Submission of Objection to Section 75W Modification of Concept Plan Approval and Project Approval – Modification no 15 Lot 6002 DP 1195858

Map A

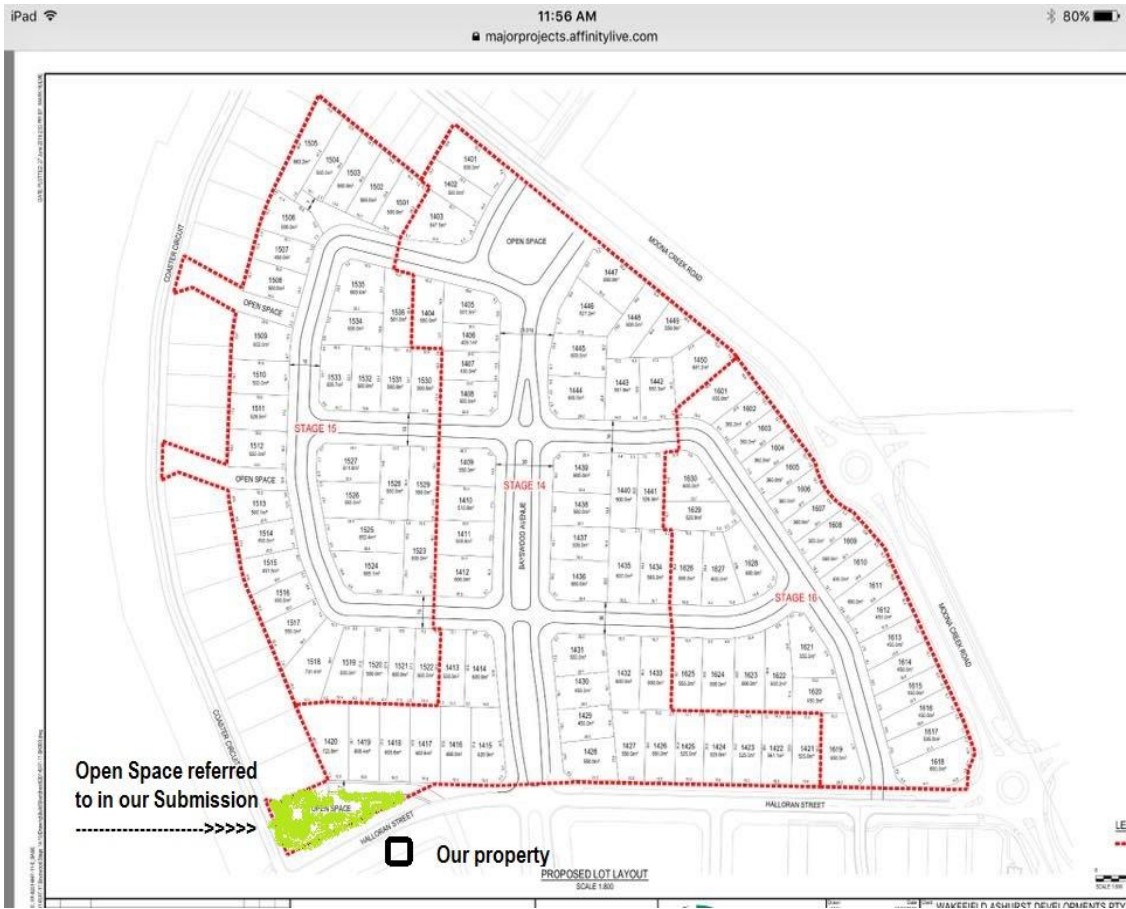
1. Objection to the size and shape of the Open Space allotment on the corner of Halloran St and Coaster Circuit (see map A)

The advertised Masterplan maps/diagrams and visual presentation for the whole Bayswood Estate have all consistently shown the same shape and size for this Open Space area. Some diagrams have also shown that this area is quite heavily vegetated with eucalypts, casuarinas and other native species. Our property is located at Lot 103 (29 Halloran St see Map A) directly opposite this Open Space area. We purchased here specifically because of the proximity to this Open Space and the visual advantage it offers. Because the Masterplan included this Open Space, we expected this to be retained in all future planning.

Our expectation was that after the development of Lot 6002, the outlook from the front of our house would be a filtered view, through a layer of vegetation in the Open Space, to the rear fences of the closest residential blocks. The Modified plan provides us with a very different and unappealing view. The addition of the Service Road and changed block-layout resulting in houses facing Halloran St, will impact on us significantly by:-

- Adversely affecting our visual amenity
- Increased noise levels
- Unnecessary increase in street lighting within the service road
- Loss of significant vegetation and bird habitat
- Traffic issues in close proximity to our property, due to vehicles accessing the service road as well as direct access from Halloran St to lots 1415 and 1416, all of which are very close (within 33 metres) to what will be the busiest intersection in Bayswood (i.e. Bayswood Ave/ Halloran St)

Photo 1

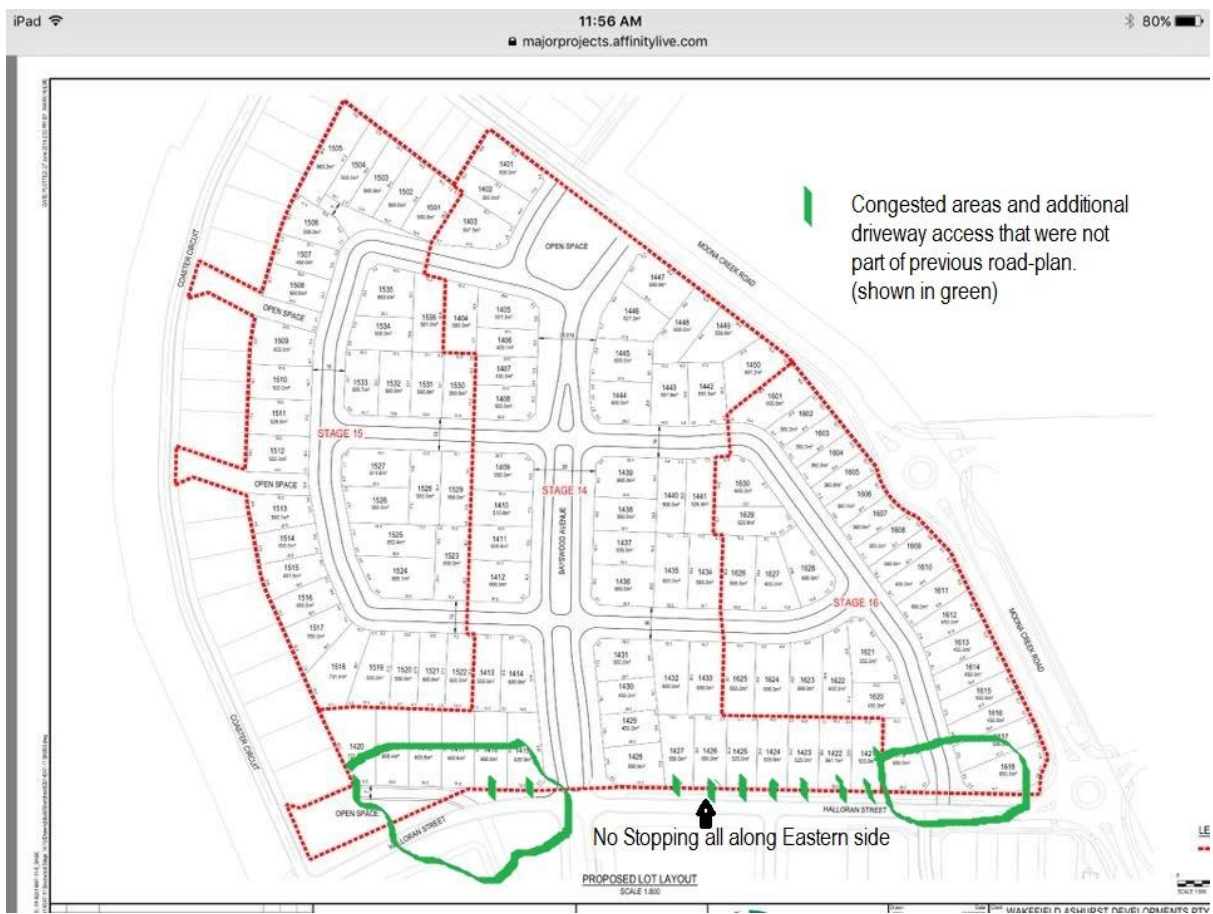
We also question the terminology "Open Space" for this plan. What is the definition of Open Space? Does this Open Space have a viable/useful size and shape for fauna and flora habitat? Will any trees be retained at all in this Open Space ?(see photo 1) There are currently several large trees in that space that are habitat for kookaburras, kingfishers, owls, cockatoos, parrots, several species of lorikeets , honeyeaters and golden whistlers.
